From: Michael Eastham
Sent: 30 October 2017 11:25
To: 'Arfon Hughes'
Cc: 'Nia Russell'; 'Ian Gledhill'; 'Tony Chapman'
Subject: FW: Salt Box, Bersted

I am currently preparing a committee report on the hybrid planning application for the Salt Box site in Bersted and I need the Local Highway Authority's view on the third level of mitigation identified in the Enterprise Bognor Regis Transport Review Report 2017 for the A29/A259 Felpham Relief Road roundabout, which I have highlighted in bold below.

The current planning application is for a new site access to the Salt Box site off the A29/A259 Felpham Relief Road roundabout.

APPENDIX 9.2
SITE ACCESS ARRANGEMENTS

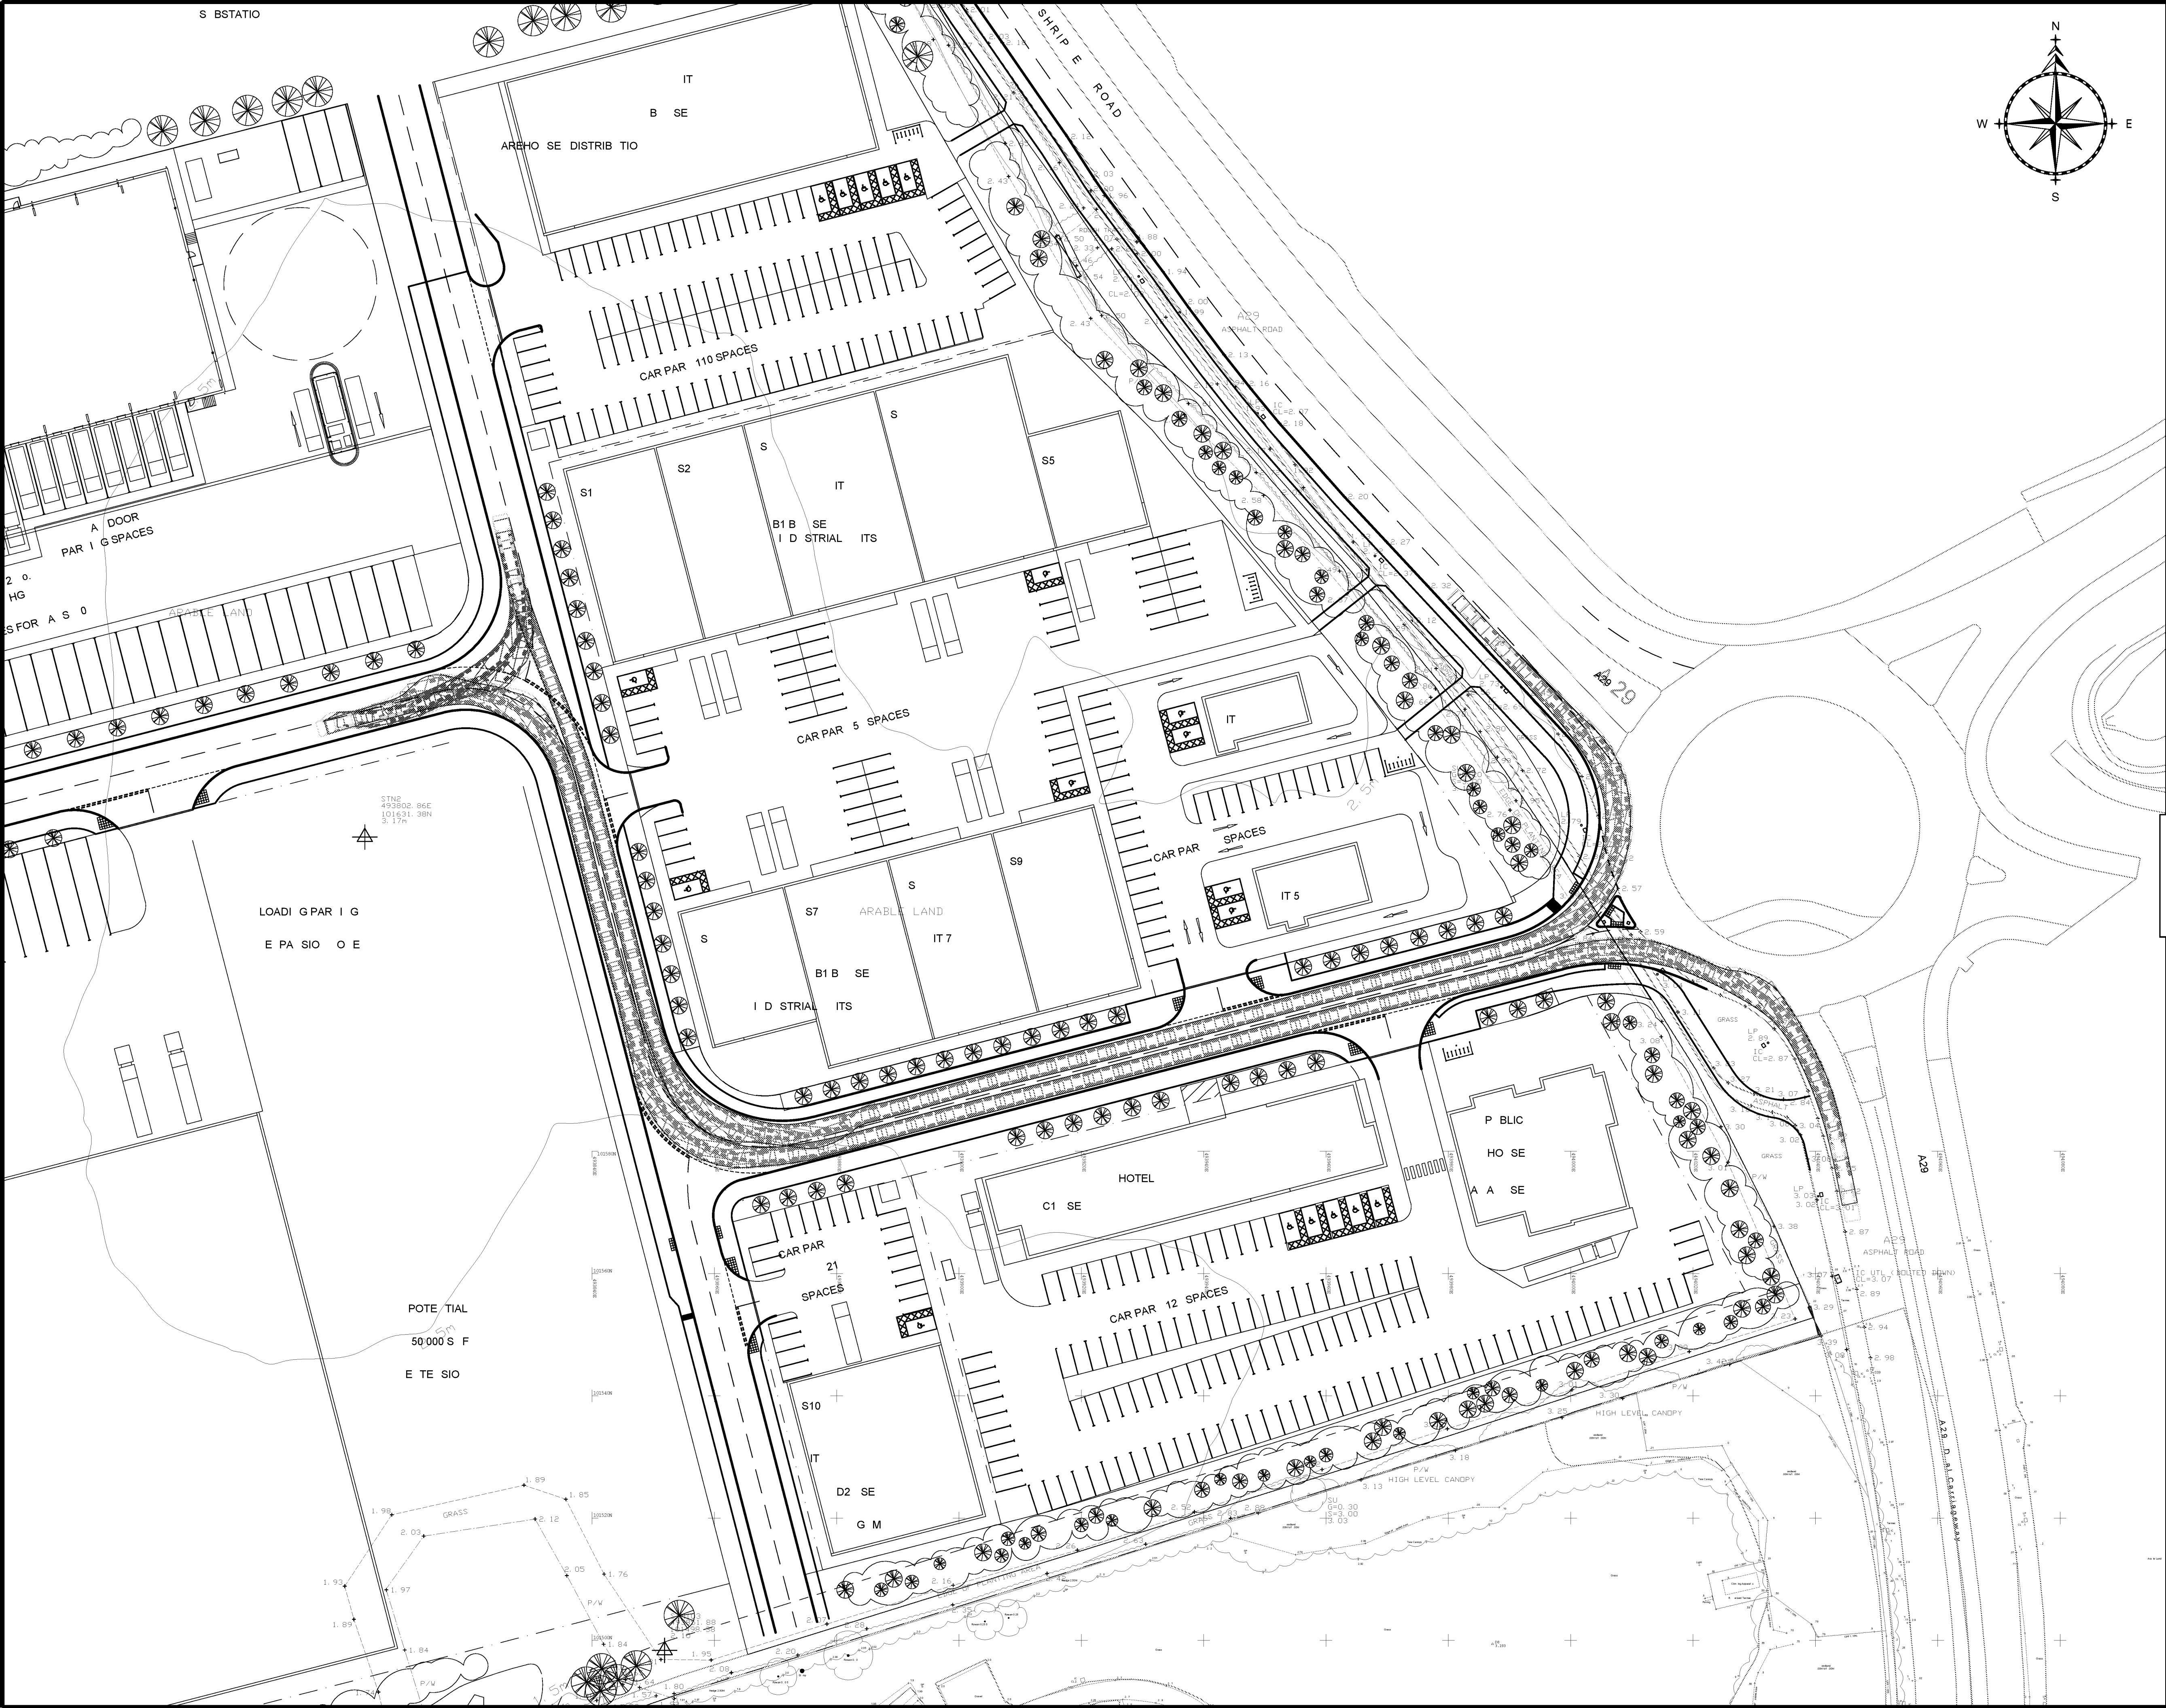
I have received the email below from Ian Gledhill including the following: "For the purposes of the current planning application, the access arrangements are acceptable. There will though need to be further work to demonstrate that the current planning application does not prejudice the mitigation as suggested within the EBR Transport Review".

The LPA needs to know what the nature of the further work is to demonstrate that the current planning application does not prejudice the mitigation as suggested within the EBR Transport Review; who will carry out the further work; and the timescale for carrying out this work?

For the purposes of the current planning application, the access arrangements are acceptable. There will though need to be further work to demonstrate that the current planning application does not prejudice the mitigation as suggested within the EBR Transport Review. WSCC will review this work, but it would be for Systra (the authors of the EBR Transport Review) to demonstrate that an alternate access is feasible and for the applicants of the current planning application to demonstrate that their site does not prejudice this.

- **The removal of the Salt Box / Rowan Park access (re-located further north on the A29).**

How should I deal with the current planning application in terms of site access proposals.
